Letter No. M/1544/05

Sub: CMDA - Planning Permission - Construction of SH² UR + GP + FF +

2FF of Residential/Commercial Building with 4 d.v. on plan no: 71B,
over no: 162/2 (new) 155(ol) T.S. no: 191, B.C. no: 24
of (Comm) village.

Development charges and other charges to be
remitted - Regarding.

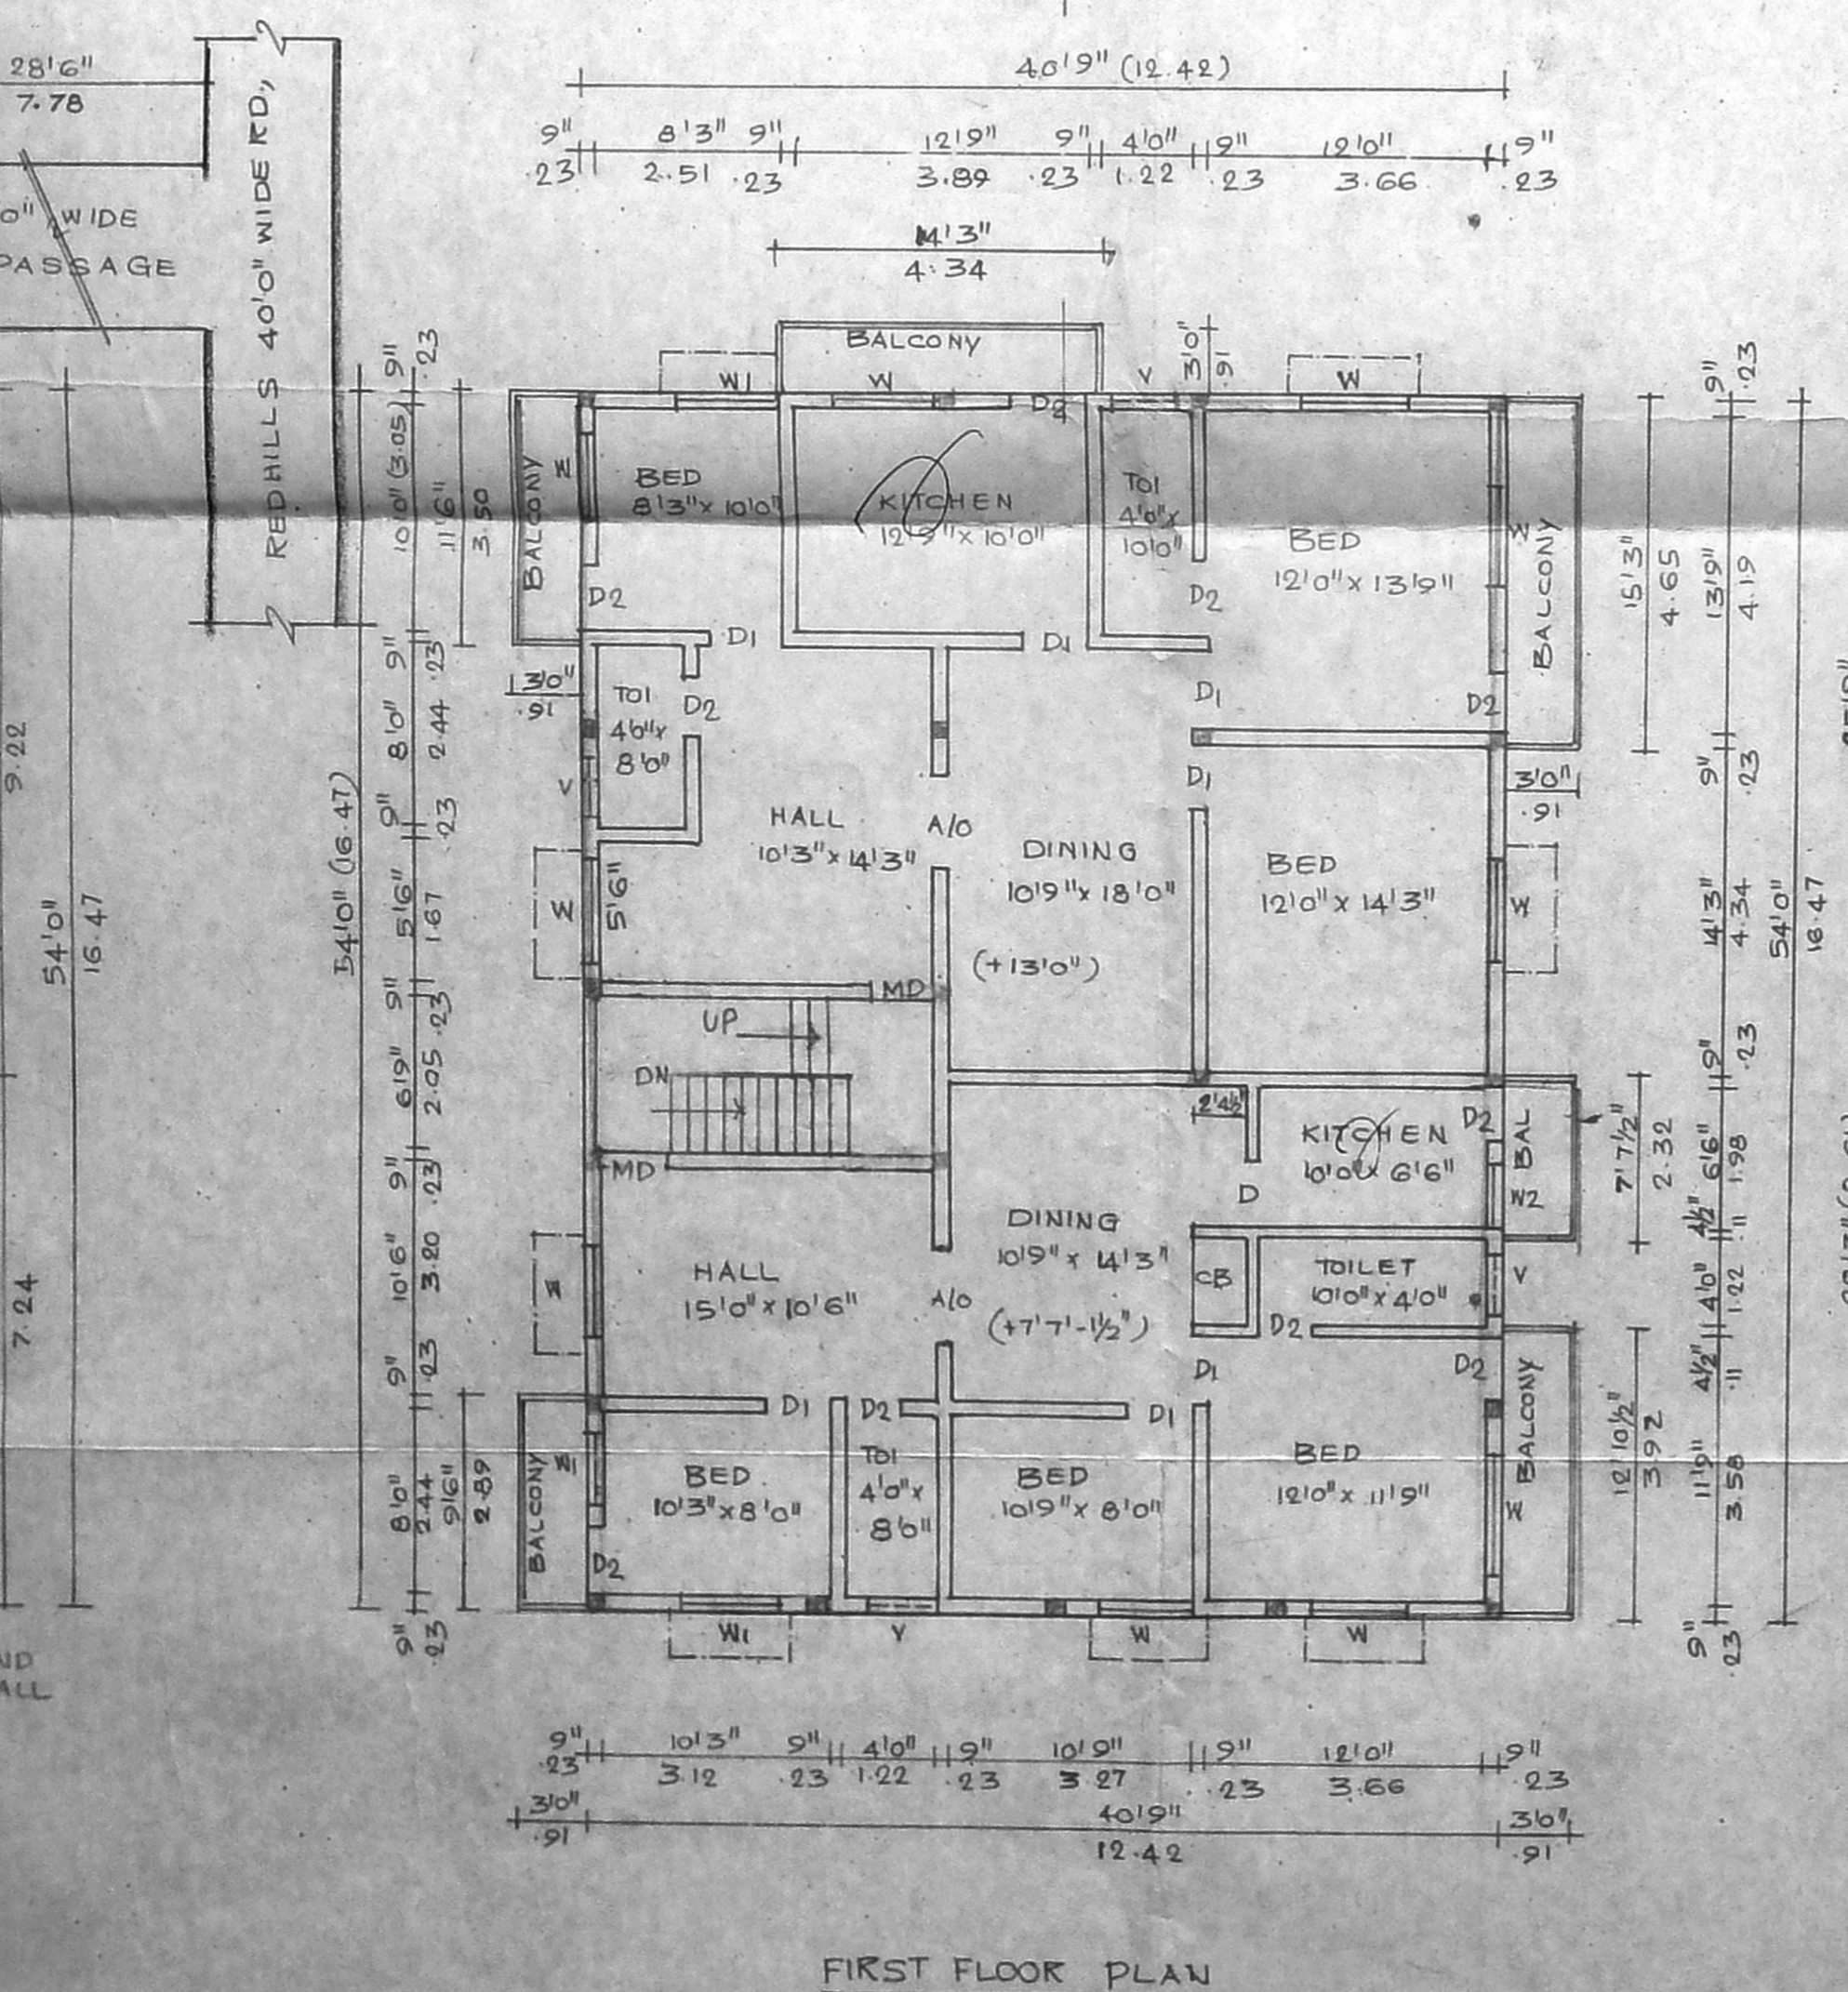
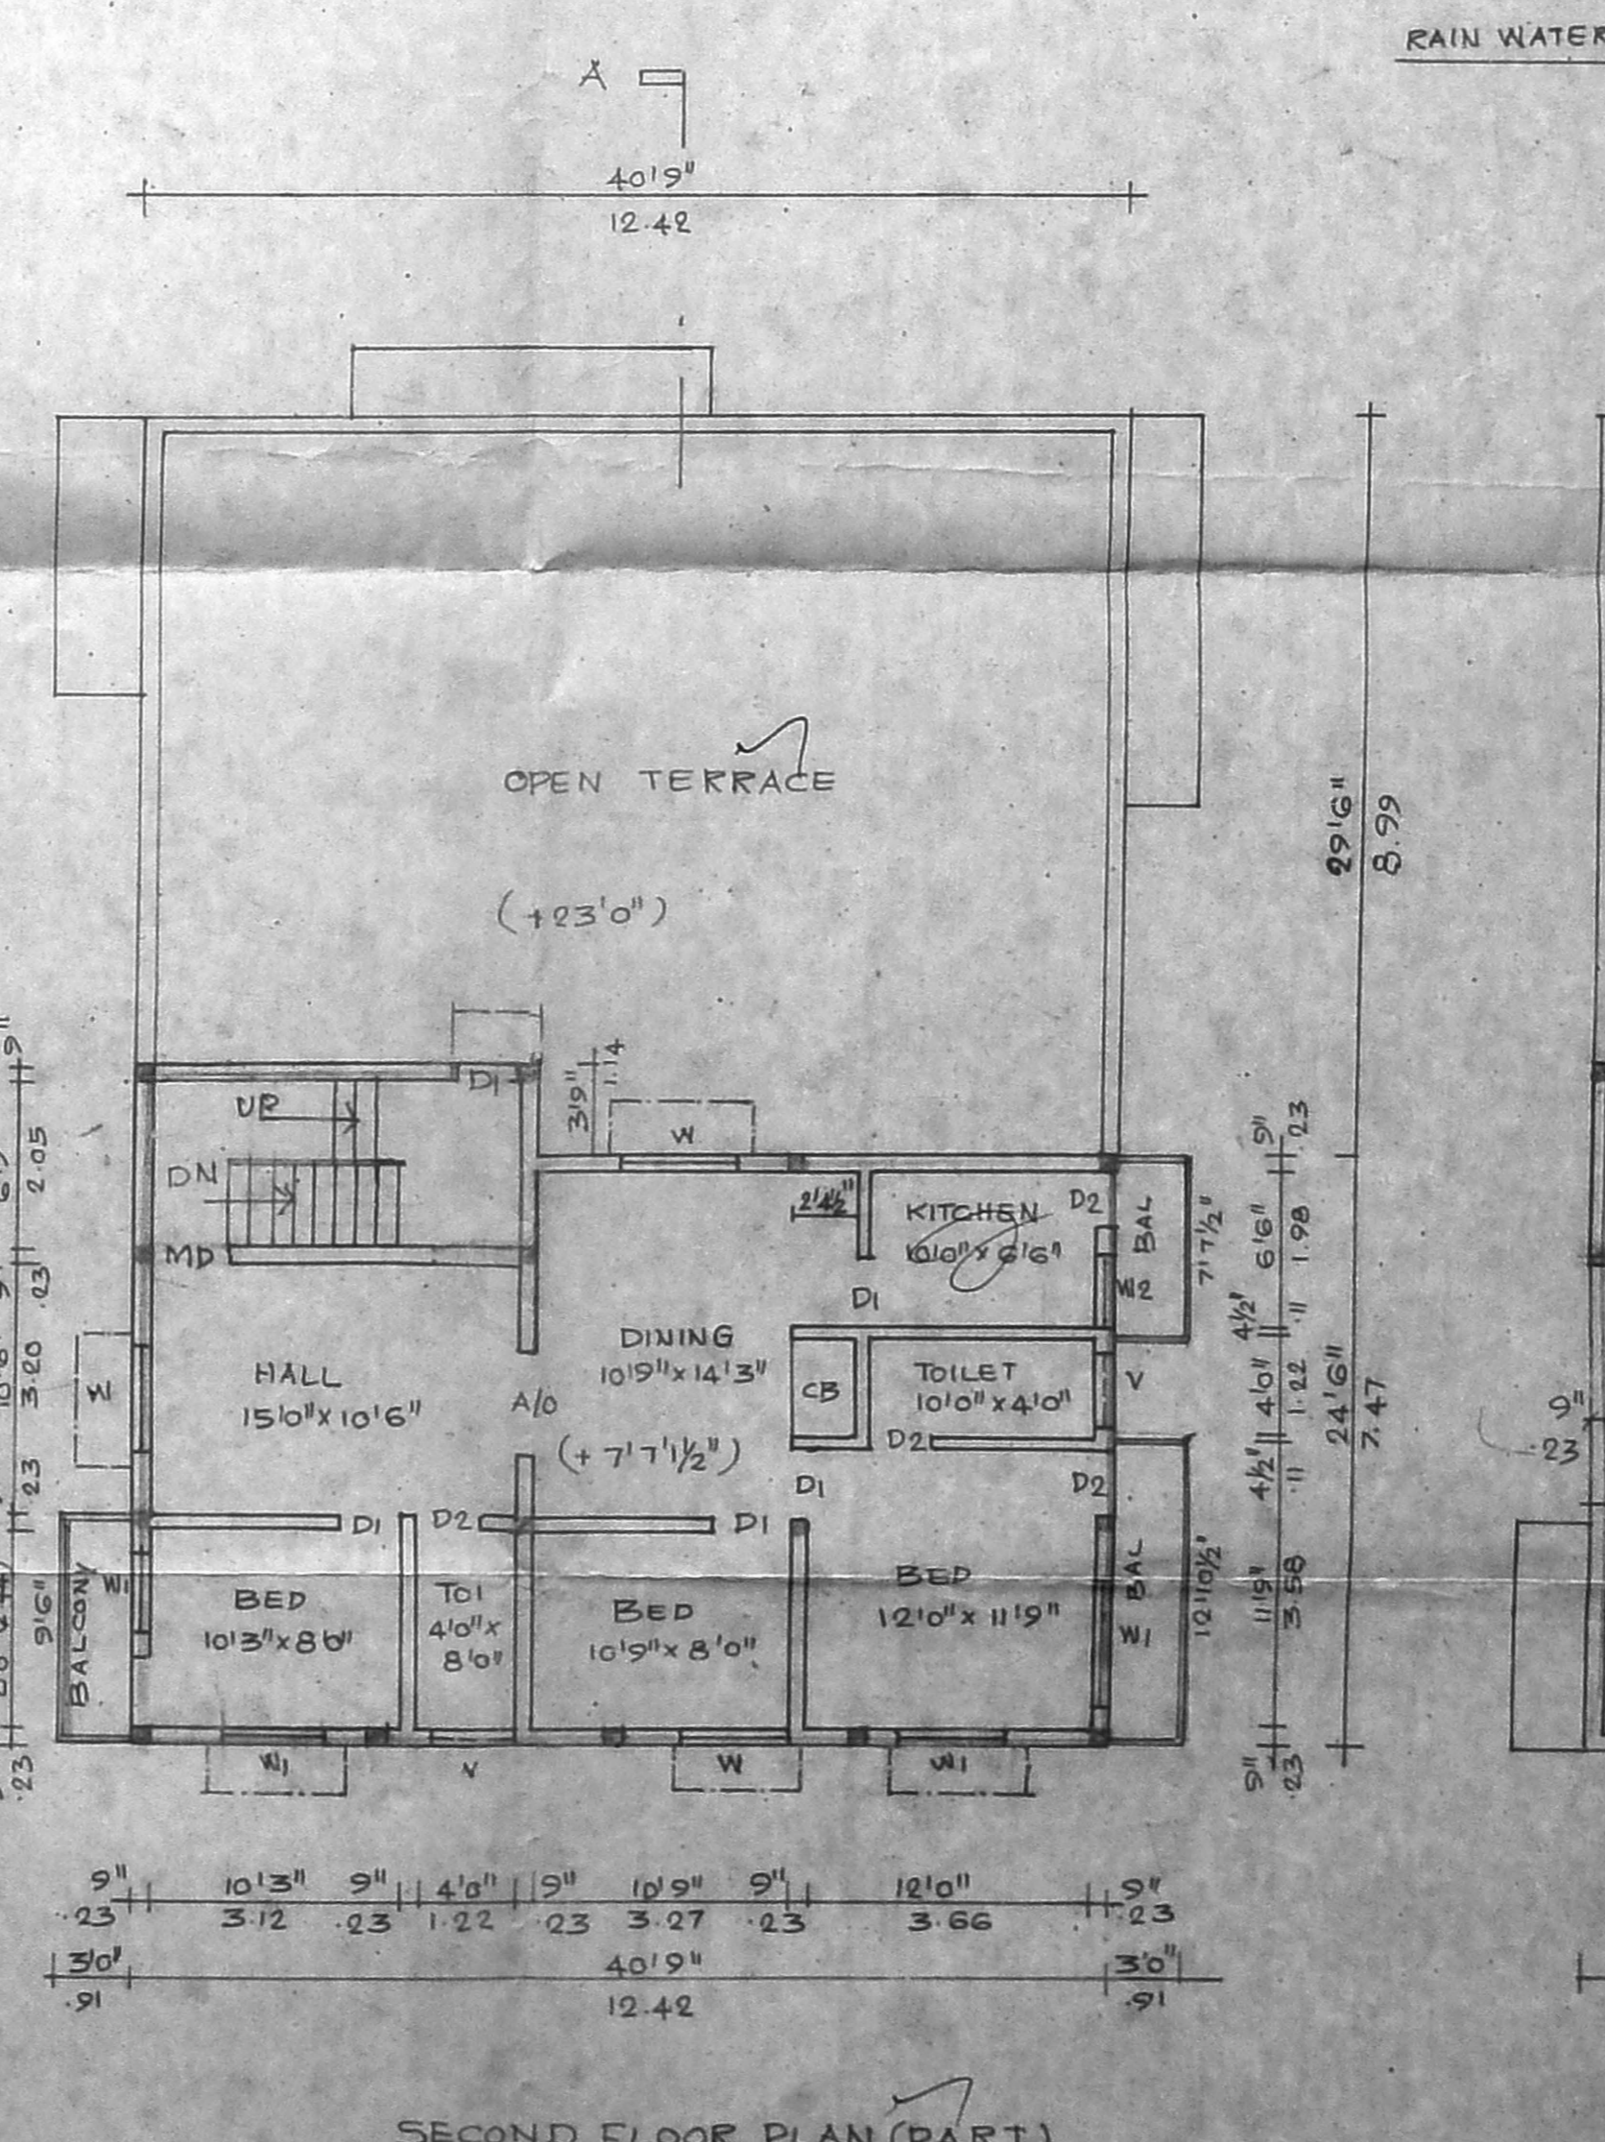
- (i) Plot no: as per SD Plan and write man title to plan.
- (ii) Now shown as show plan is not feasible.
- (iii) Elevation to be covered w.r to window/door @ hill.
